Submission ID: SC6F5EEC4

Please find attached document detailing my objection to the East Pye Solar submission based on the impact to my home environment and life on Saxlingham Green,
I also wish to endorse my support for the Block East Pye Solar (BEPS) and Saxlingham Nethergate Parish Council submissions of Relevant Representation.

Figure 11.8: Likely and Suitable Routes to the Scheme

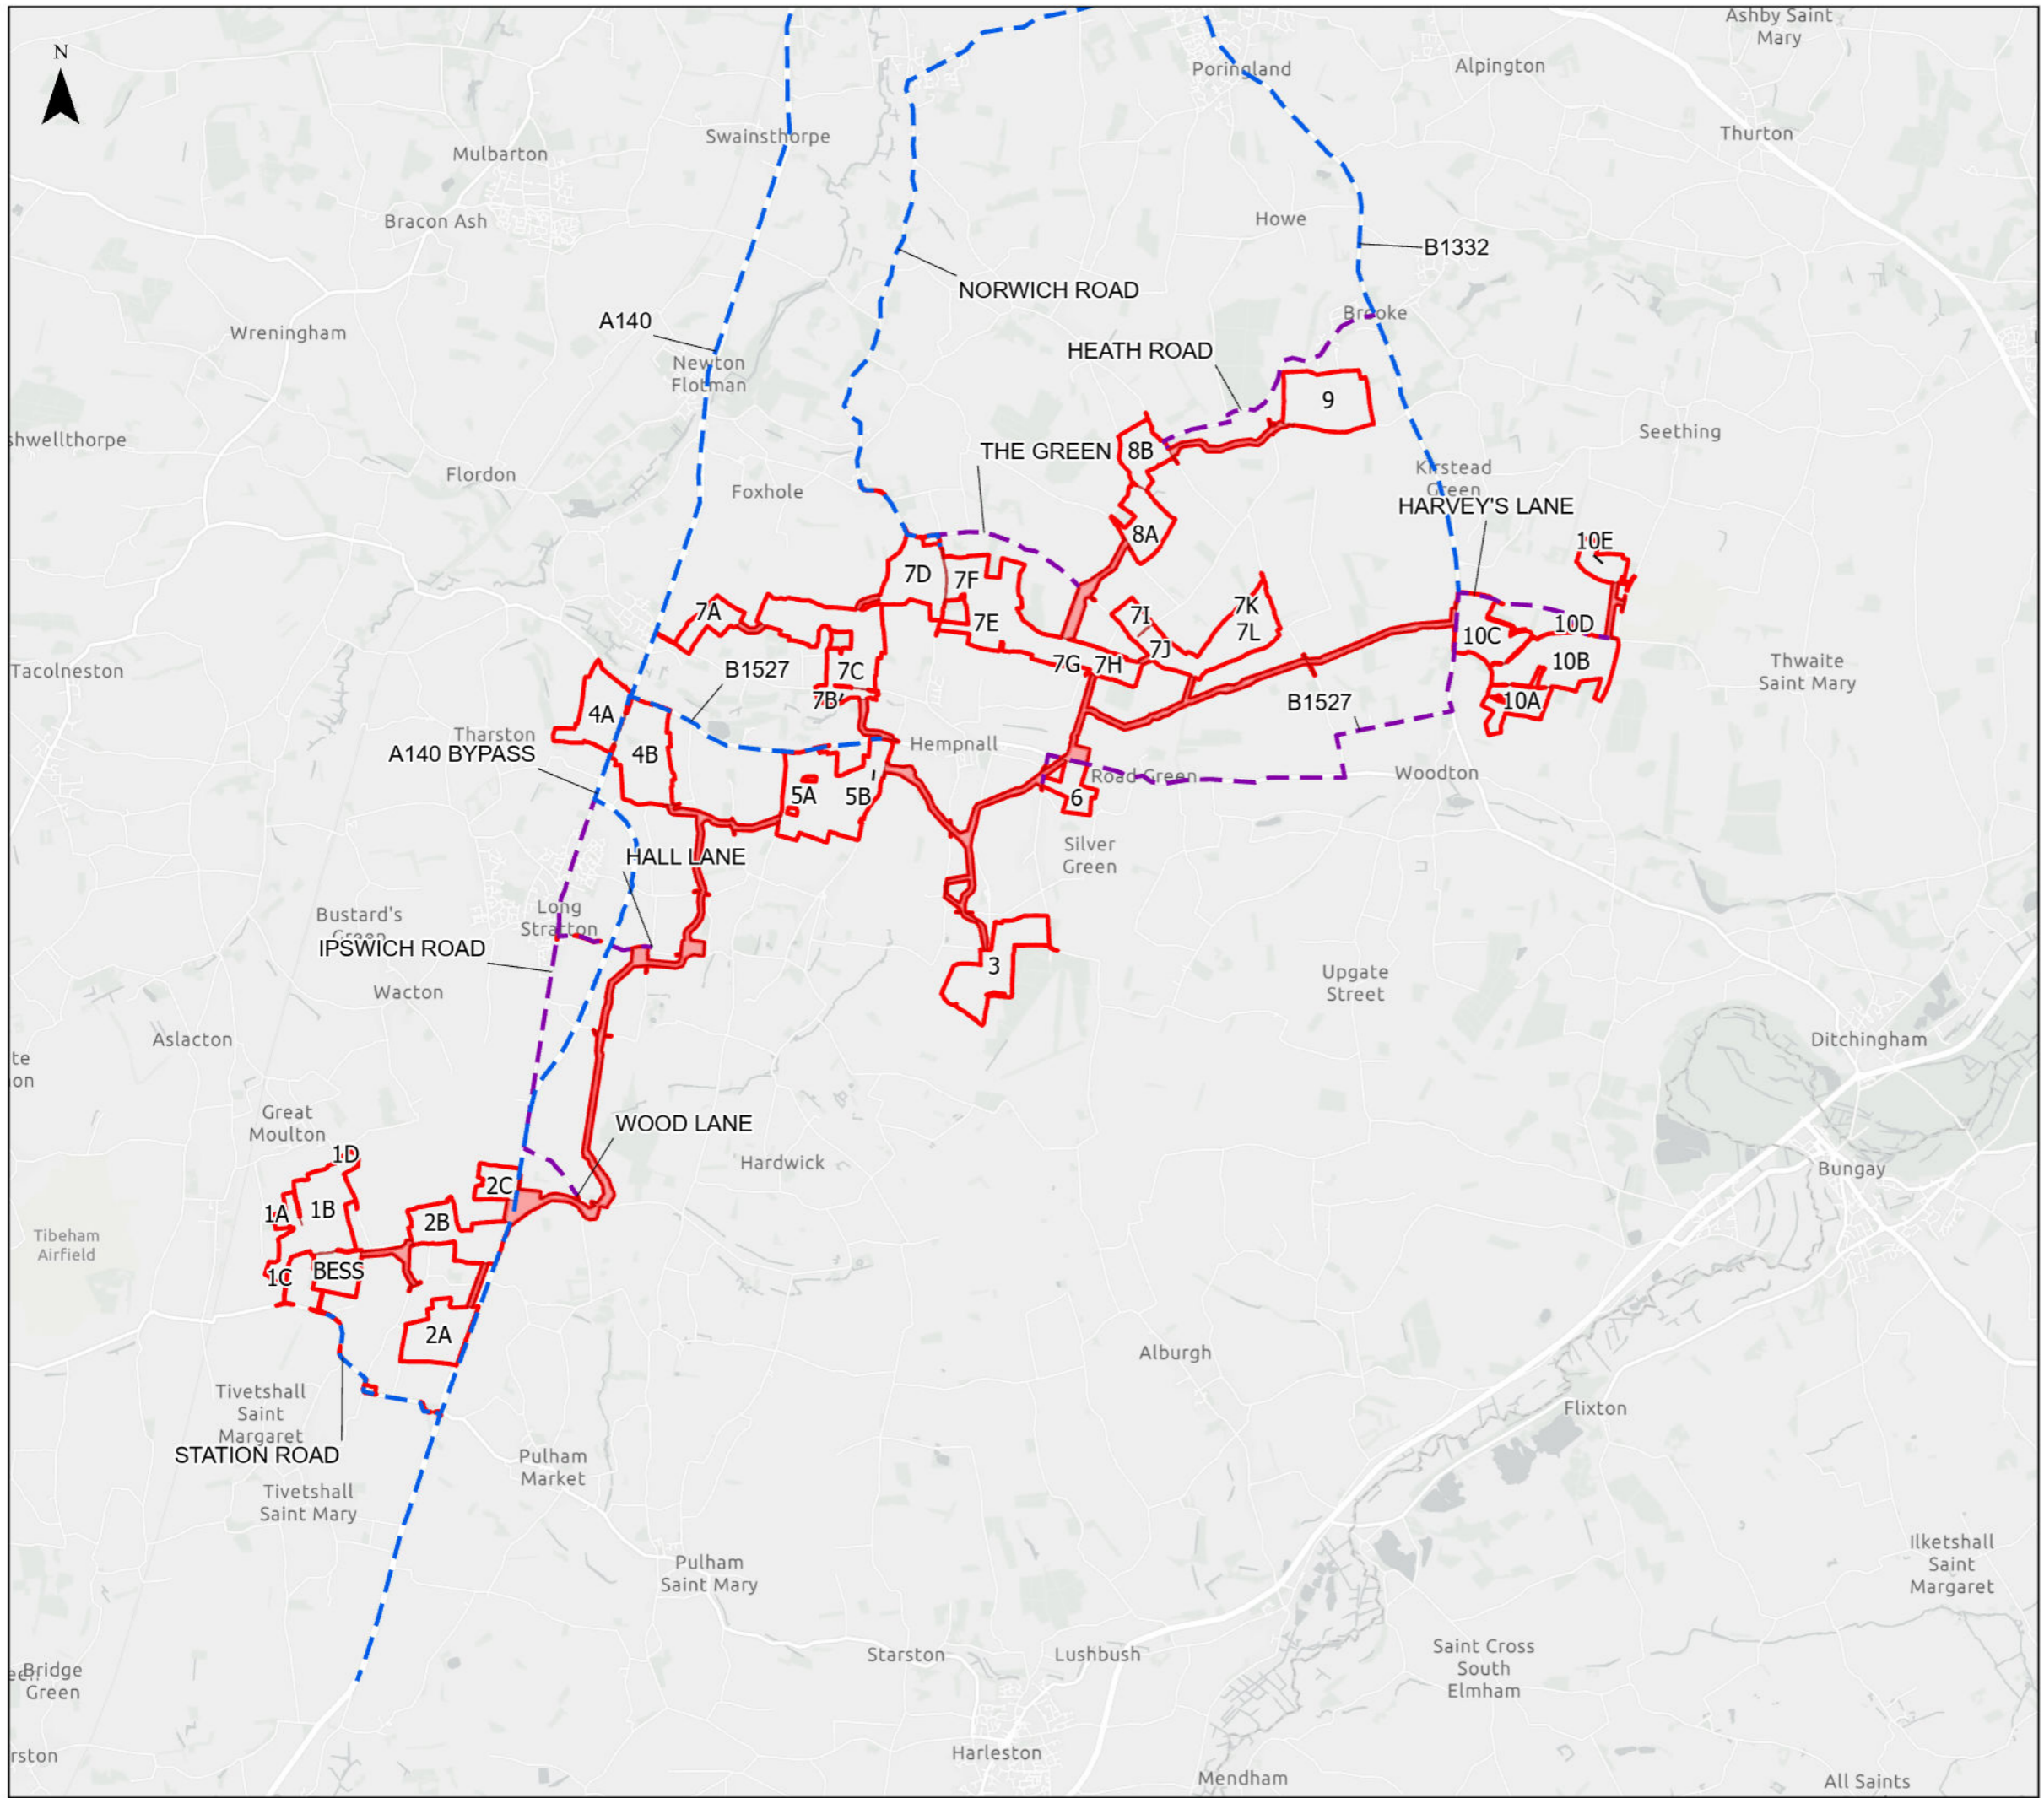
Our house on the green is on the proposed AIL route, which will severely impact our lives, from noise, pollution, vibration, lack of sleep.

Our house is 300 hundred years old and built of clay lump and is not able to cope with vibration. The rainwater drainage systems that surround our house and the green will become blocked due to HGVs constantly trampling over them as the lane is not wide enough to accommodate safe access.

- In summary: Traffic disruption from additional and heavy goods traffic on local roads for a long period of time (noise pollution, diversions and potentially blocked roads etc) and the proposed AIL route for indivisible loads, is totally inappropriate for an unclassified narrow road across a conservation area lined with ancient dwellings.
